Catherine-de-Barnes Residents' Association

Response to written and verbal representations made at Deadline 2

1) HE Lighting Technical Note Published 27/6/19

M42 Junction 6 DCO – (scheme TR010027) Document Junction 5A Operational Assessment – published June 2019

Drawing Number
HE551485 -ACM -HLG -

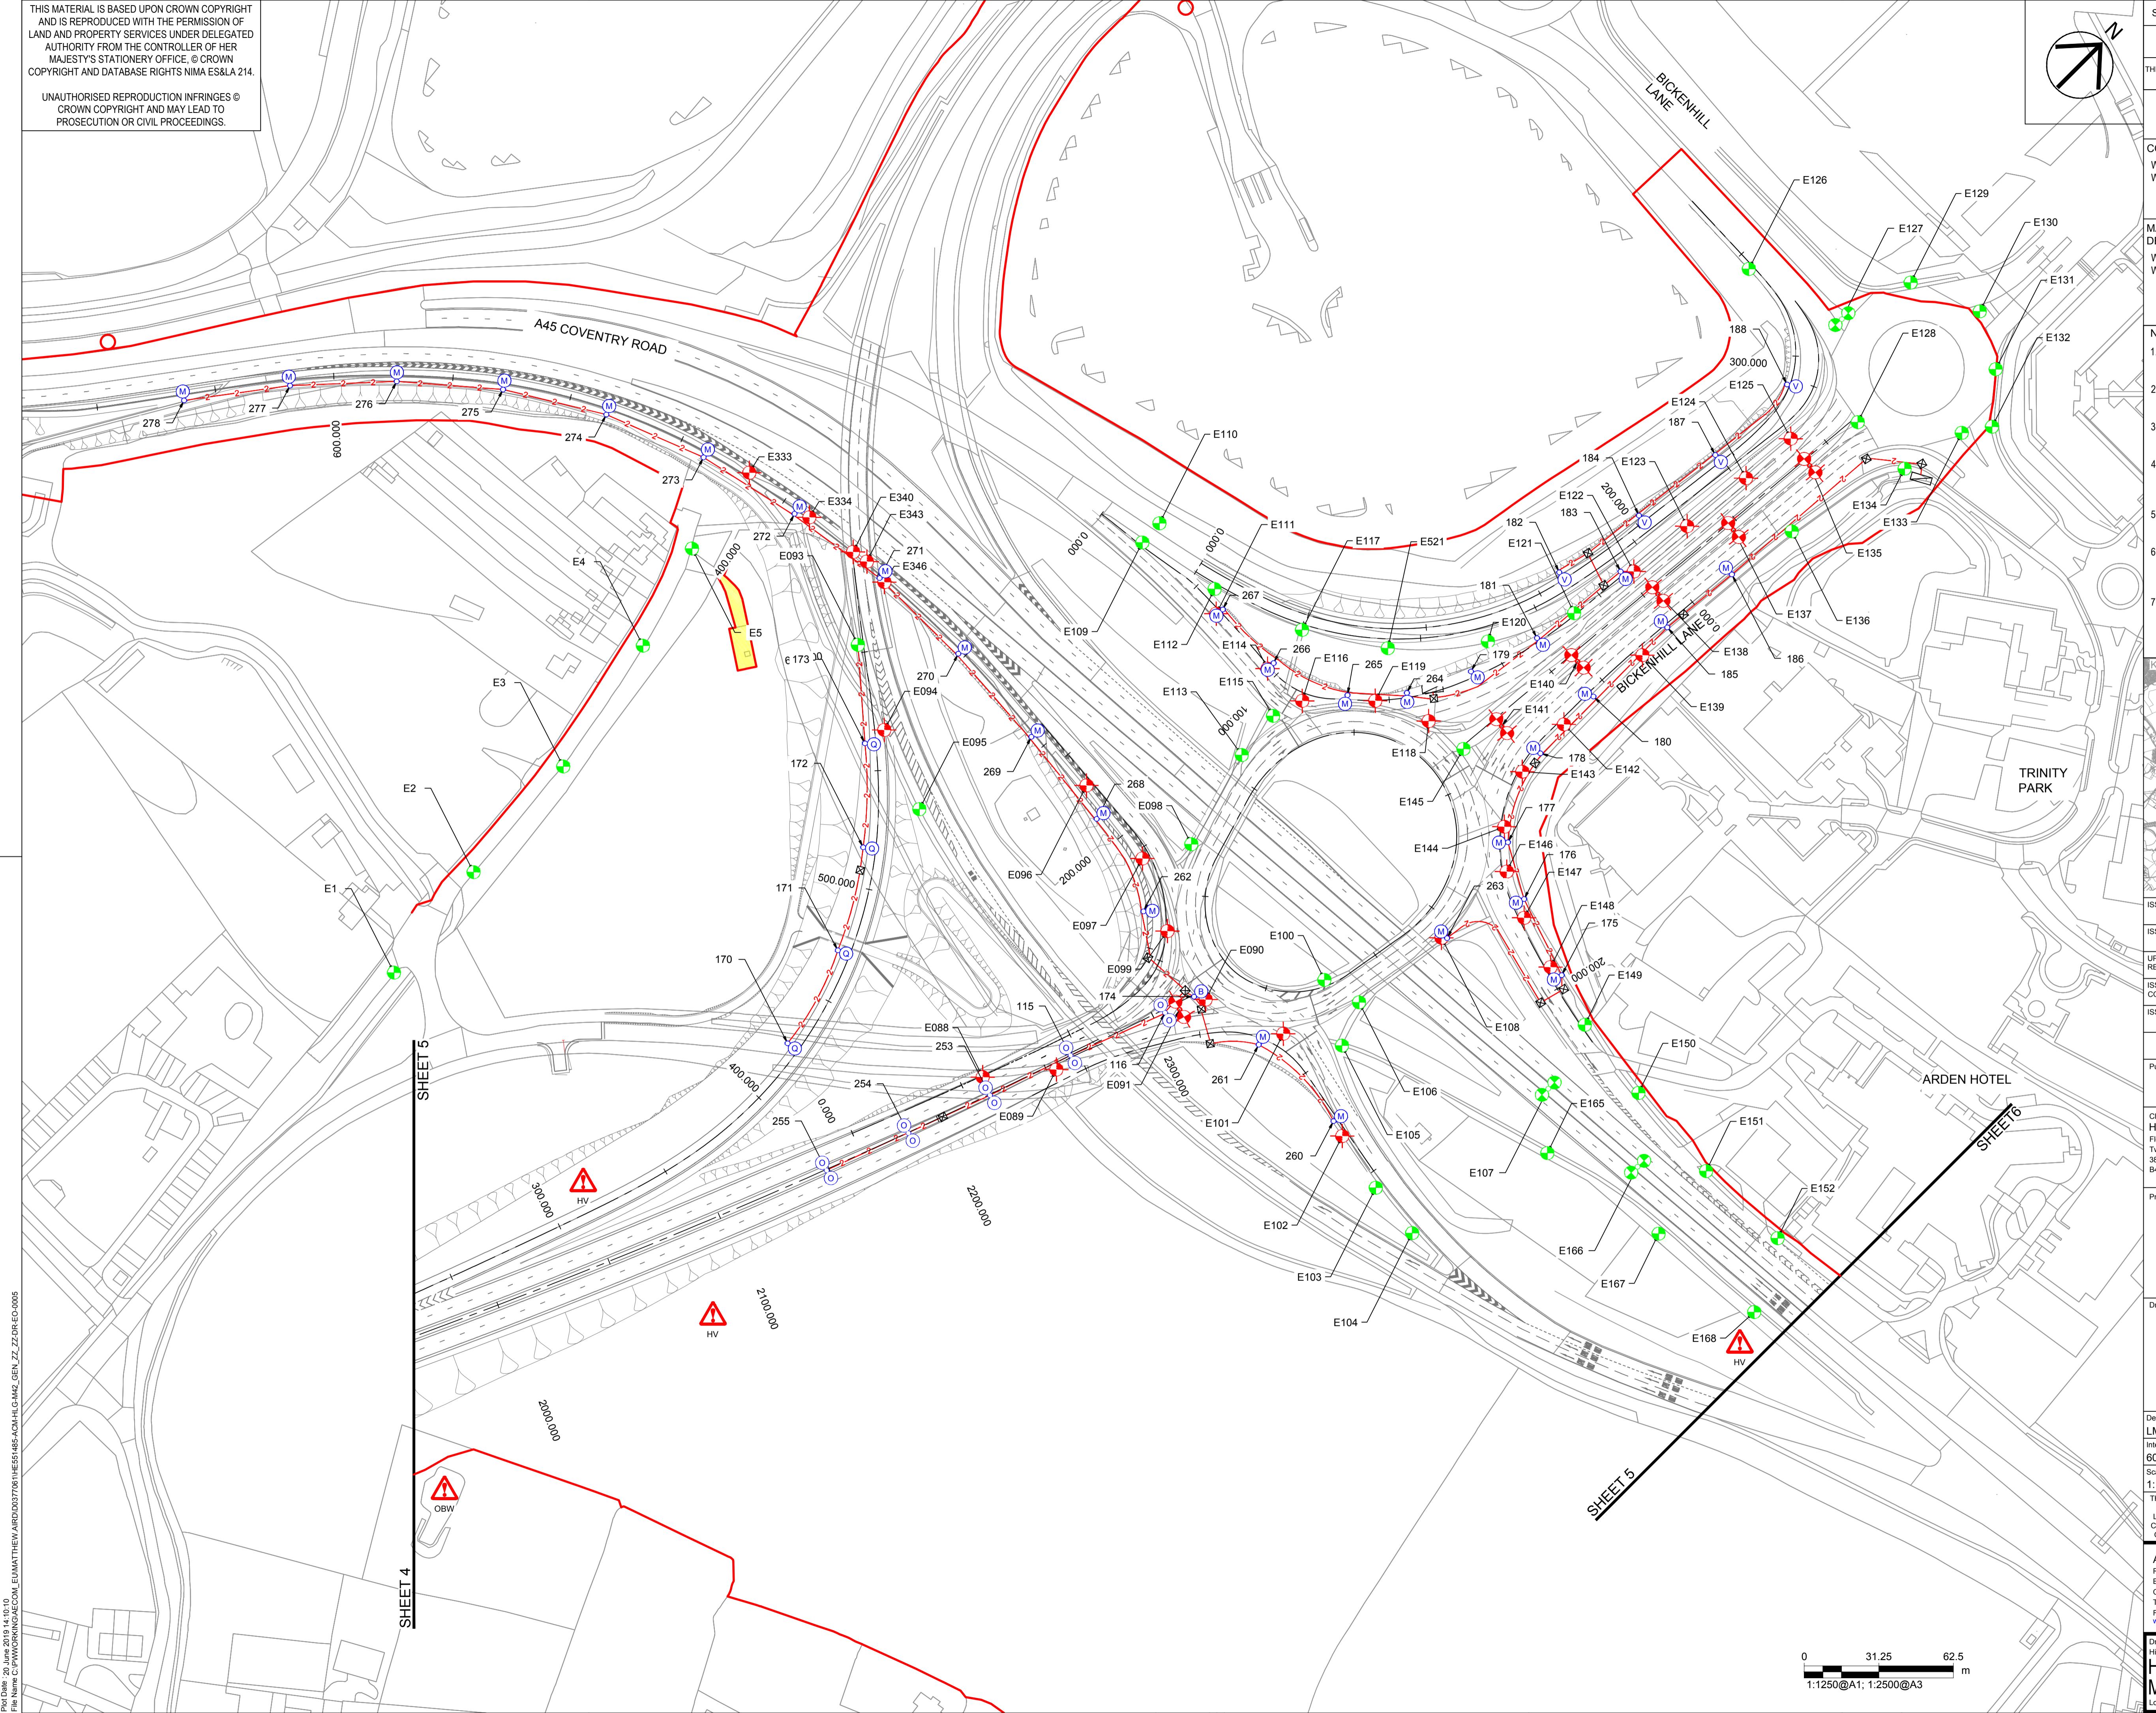
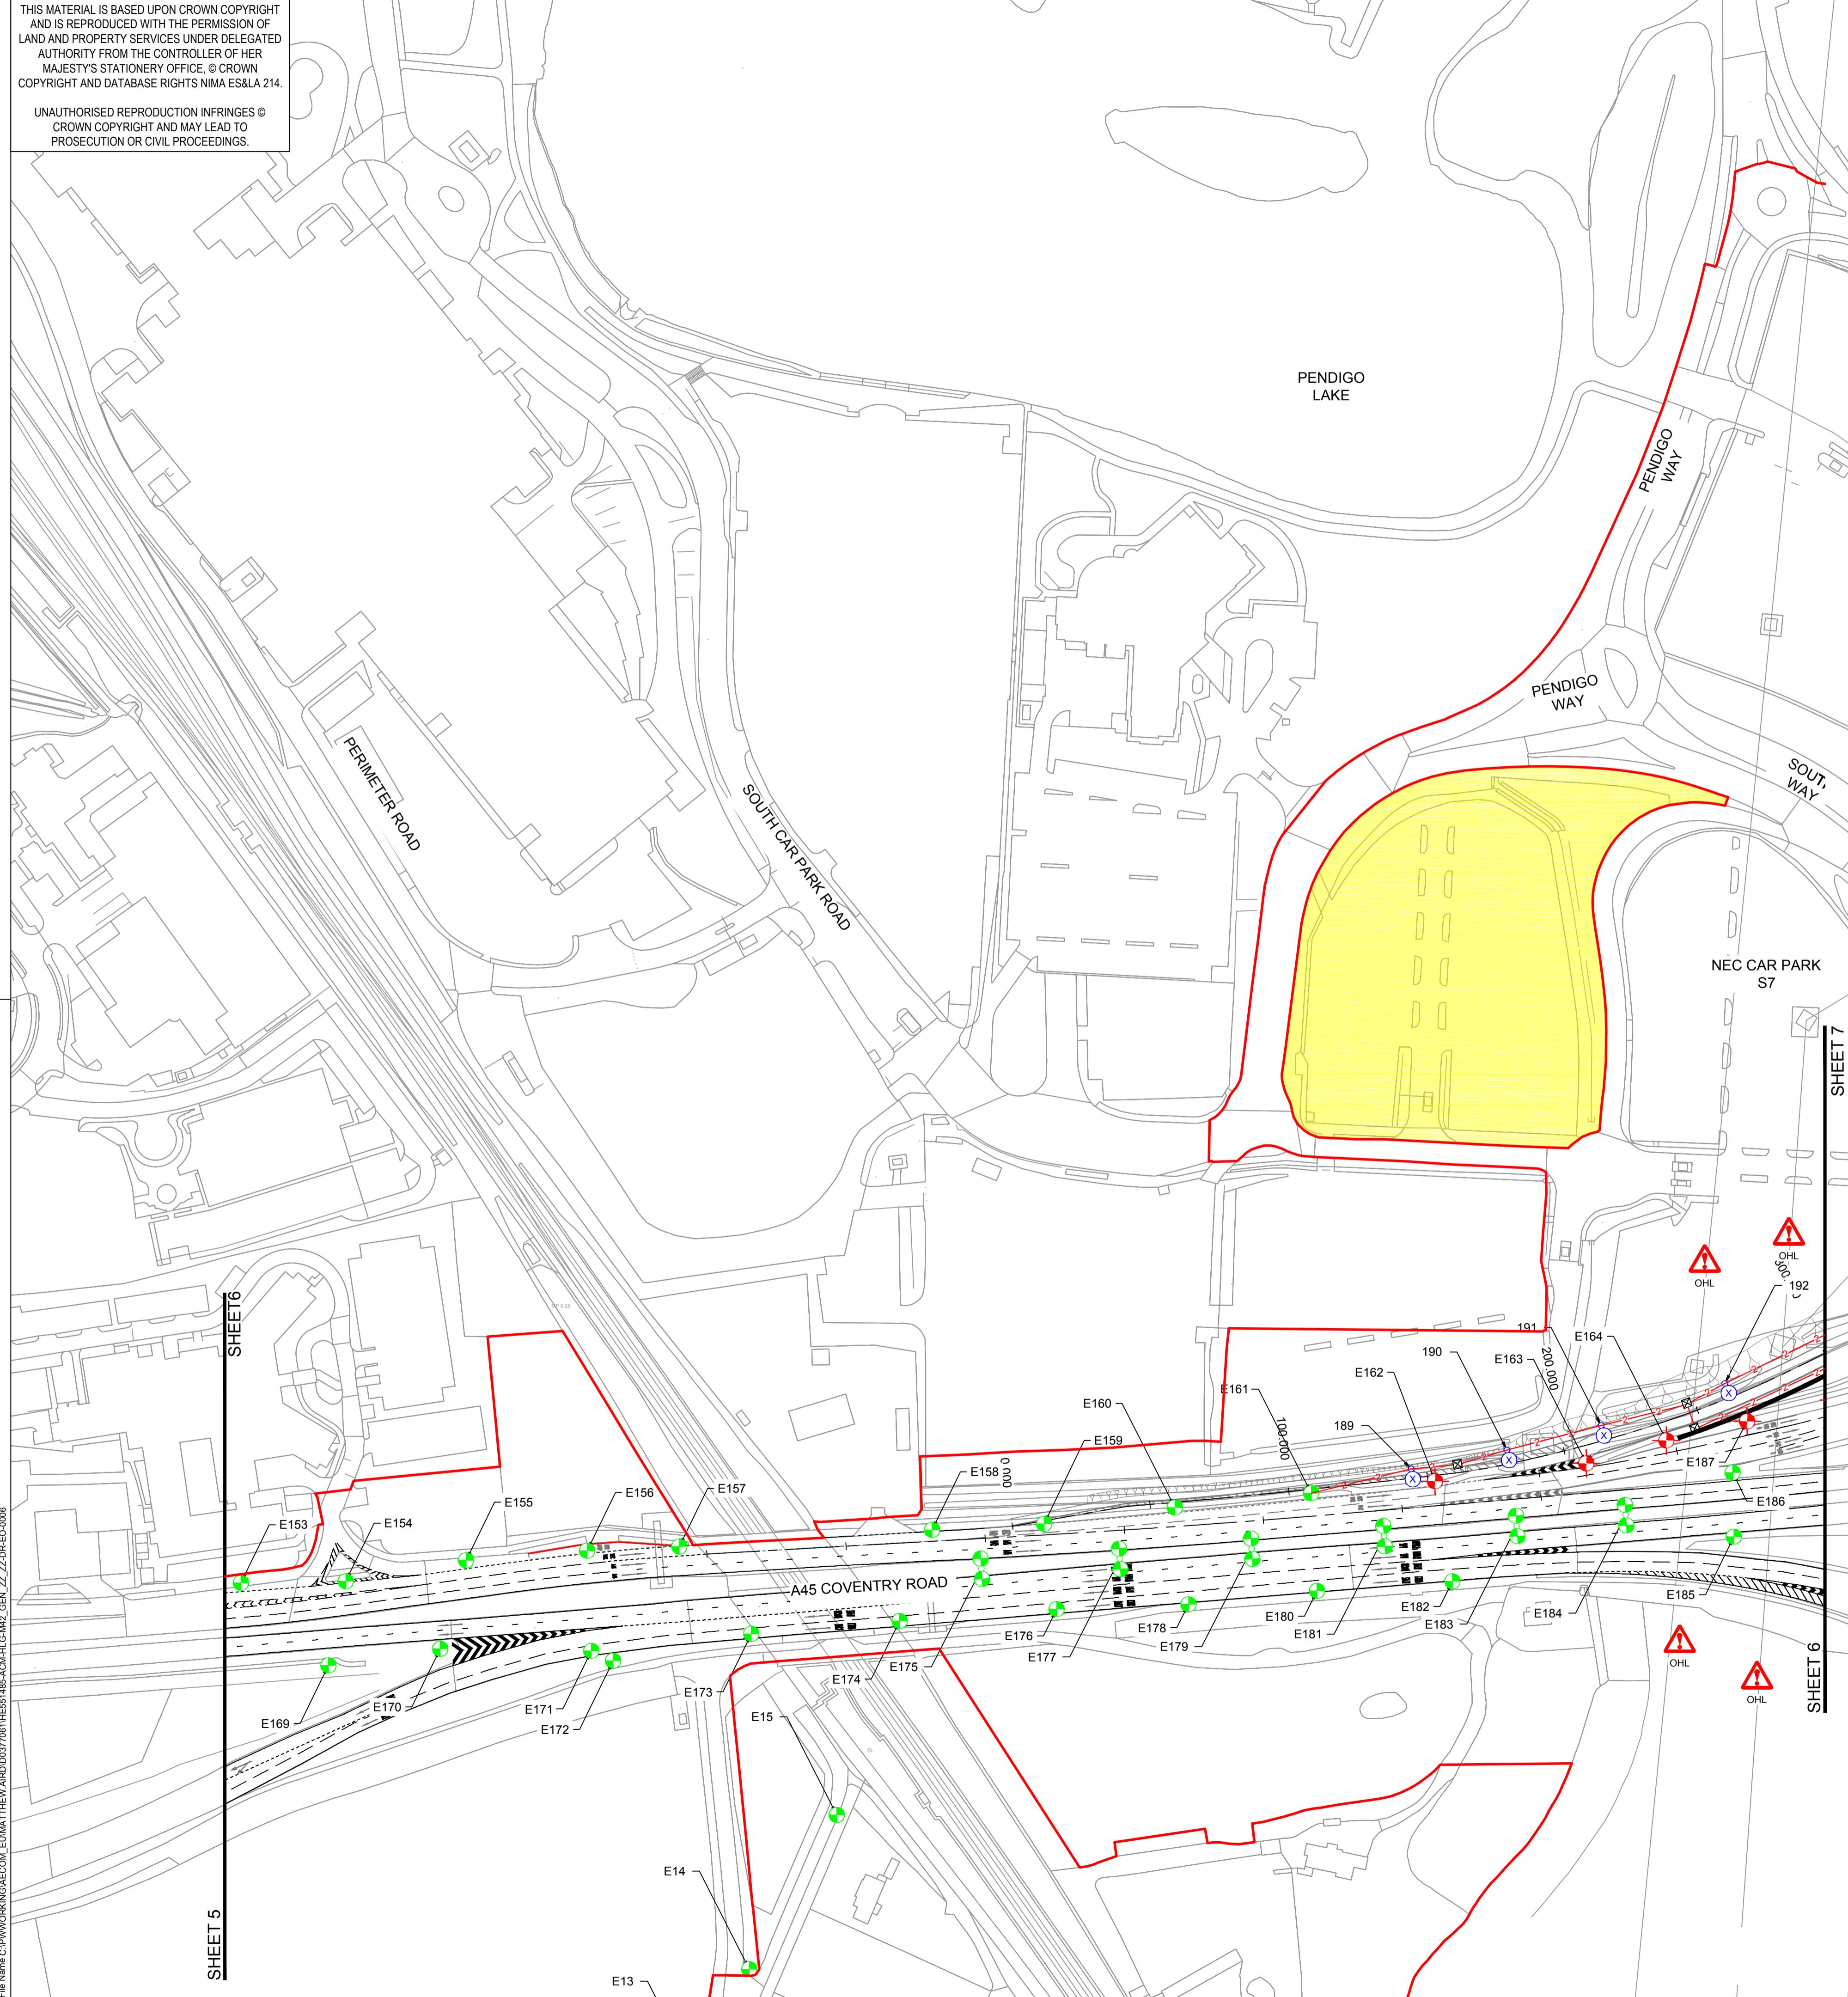
We note that it is the intention to light Barbers Coppice Roundabout and the entry/exits off it but Bickenhill Roundabout and Catherine de Barnes Lane North Overbridge are not to be lit largely because of the environmental /social impact – the surrounding lanes are not lit. Currently Catherine de Barnes Lane (where the Barbers Coppice Roundabout (BCRT)is to be sites) is not lit and we challenge the decision to light it as proposed. From our recollection the speeds of traffic at the BCRT is likely to be 40/50mph but that traffic approaching the Bickenhill Roundabout could be at speeds

of 70mph which would suggest that for safety reasons this roundabout should be lit. The lighting of BCRT severely impact the property of Four Winds. There appears to be further contradiction vis a vis the M42 Southbound Diverge Slip for Jct 6. There will be an apparent saving of 0.13PIA's in year 1 (3 PIA's in yr30) and has a BCR of 2.36 which is described in Table 5 Conclusions and Recommendations – page 17 as a “low BCR” and HE recommends that *“although BCR highlights street lighting is not justifiable for the slip road”* it is recommended for safety reasons.

In comparison Barbers Coppice roundabout will apparently save 0.09PIA's in year1 (2 PIA's in 30 yrs) both figures lower than the M42 Southbound diverge mentioned above. The Coppice Roundabout has a BCR of 2.2, again lower than the slip road mentioned above, yet HE recommends it being lit. There appears to be a distinct lack of consistency and reasoning in arriving at this Lighting Scheme.

The proposed lighting scheme has not been the subject of or included in any public consultation.
